From: Fiona Fitzgerald <Fiona.Fitzgerald@arun.gov.uk>
Sent: 20 January 2020 12:34
To: Planning.Responses <Planning.Responses@arun.gov.uk>
Cc: Karen Garner <Karen.Garner@arun.gov.uk>
Subject: AL/106/19/DOC

Environmental Health are happy with the EV charging points and are happy for Condition 15 to be discharged.

In summary, Environmental Health are happy for Condition 15 to be discharged, but require further information on Conditions 7 and 10.

REV. No.	DATE	DESCRIPTION	INITIALS
Client			
Project	Westergate & Eastergate		
Title	External Works Layout Sheet 1	Scale 1:250@A0 Checked AMc	Date Mar '18 Drawn KT
Drawing No.	5655:40	Rev	H

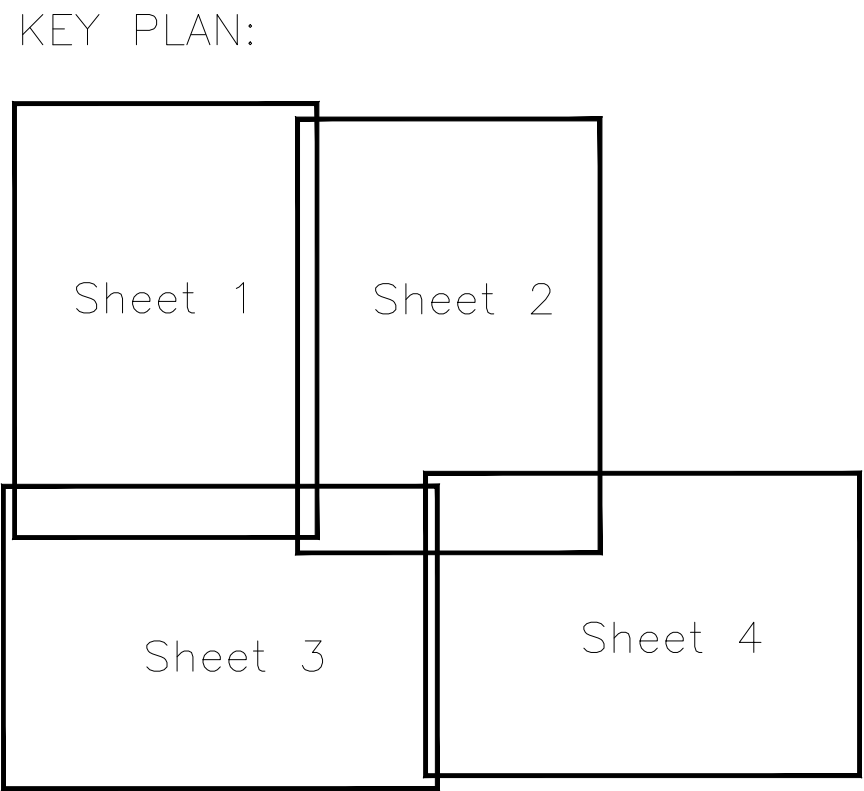
Lighting – condition 7, some lighting was shown on one of the engineers maps, but I couldn't find any confirmation within the application that the lighting scheme proposed complies with the Institute of Lighting Professionals Guidance Zone E2. Please could this be confirmed.
